Lime Down

Solar Park

Written Summary of the Applicant's Oral Submissions and Responses at Issue Specific Hearing 6 and Responses to Action Points

Document Reference: EXAM/9.81

Title: Figure 3-3: 400kV Substation and BESS Layout

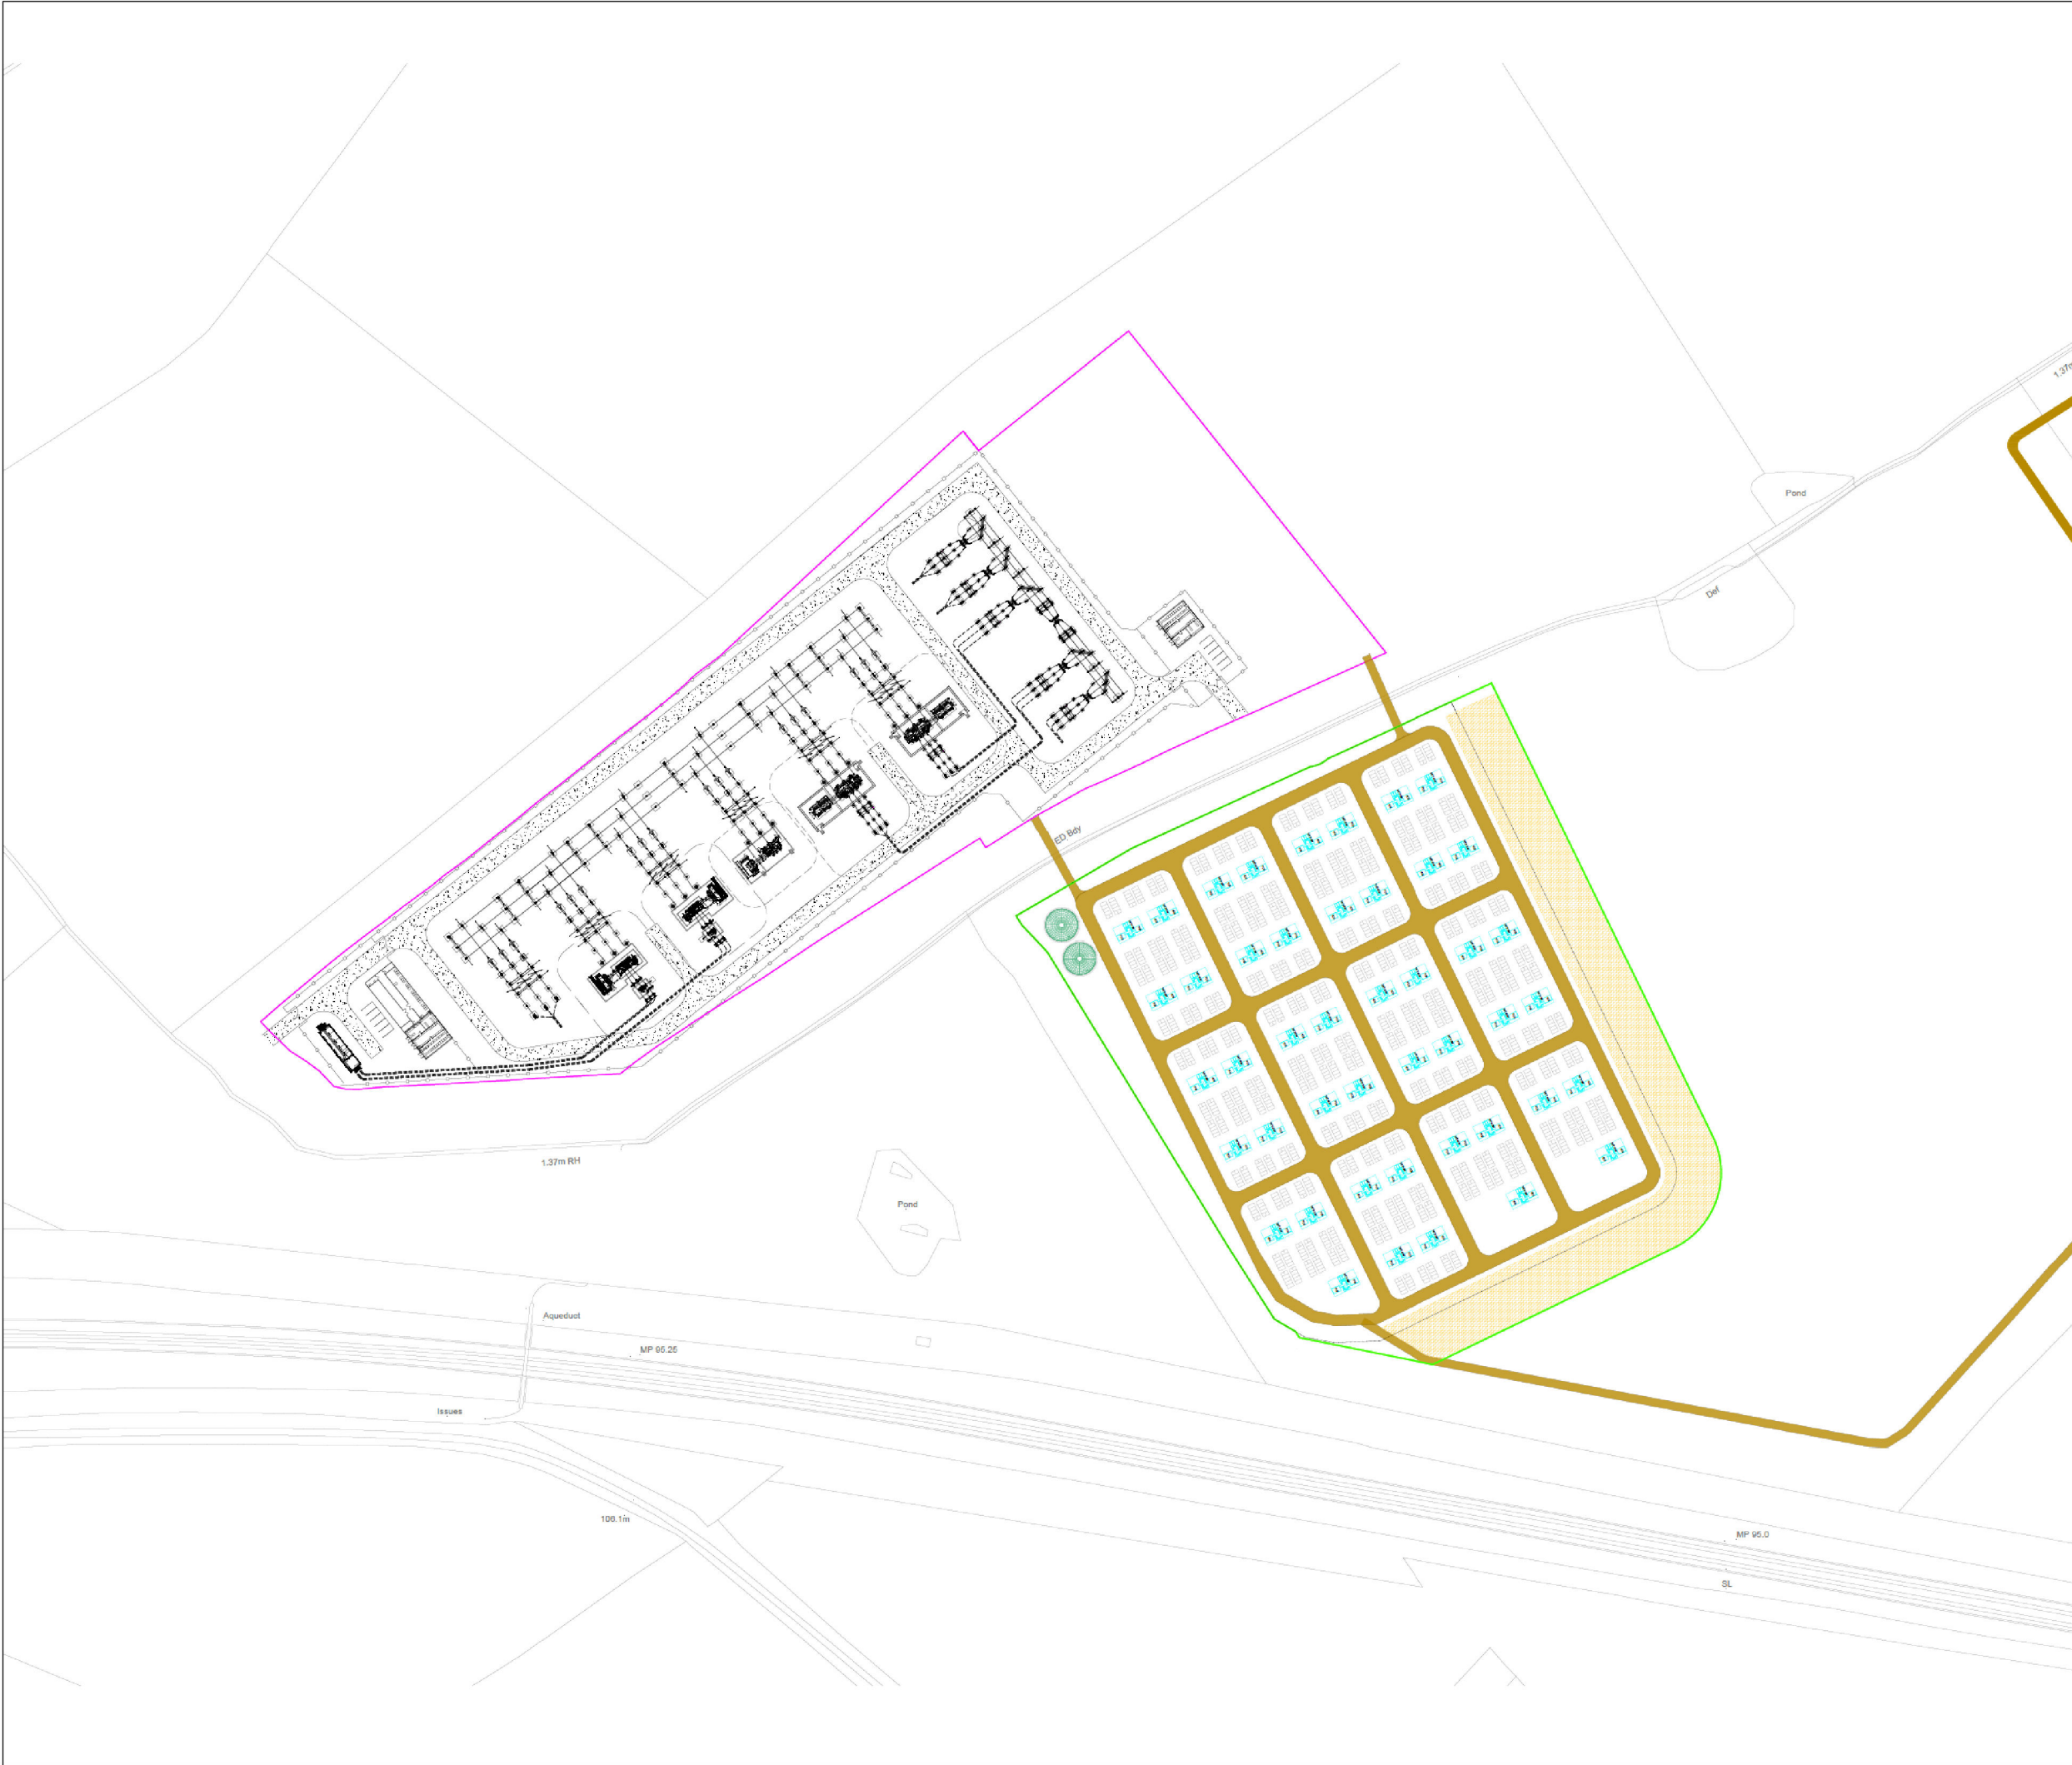
section 11, show about 7.2%. Concrete deliveries generate a lot of HGV trips; this is an overestimated. Similarly, with the 400KV substation, the Application overestimated it at 49%, but it is more likely at 5%, see Environmental Statement Volume 2, Figure 3-3 400 kV Substation and BESS Layout [APP-083] figure 33 which shows that. The ExA asked whether the access tracks are needed during construction, to which Mr Darrall confirmed that some are needed earlier than others because of phasing. The Applicant can reuse the aggregate and top up the access tracks within the existing areas. This will be done on Westburn for example.
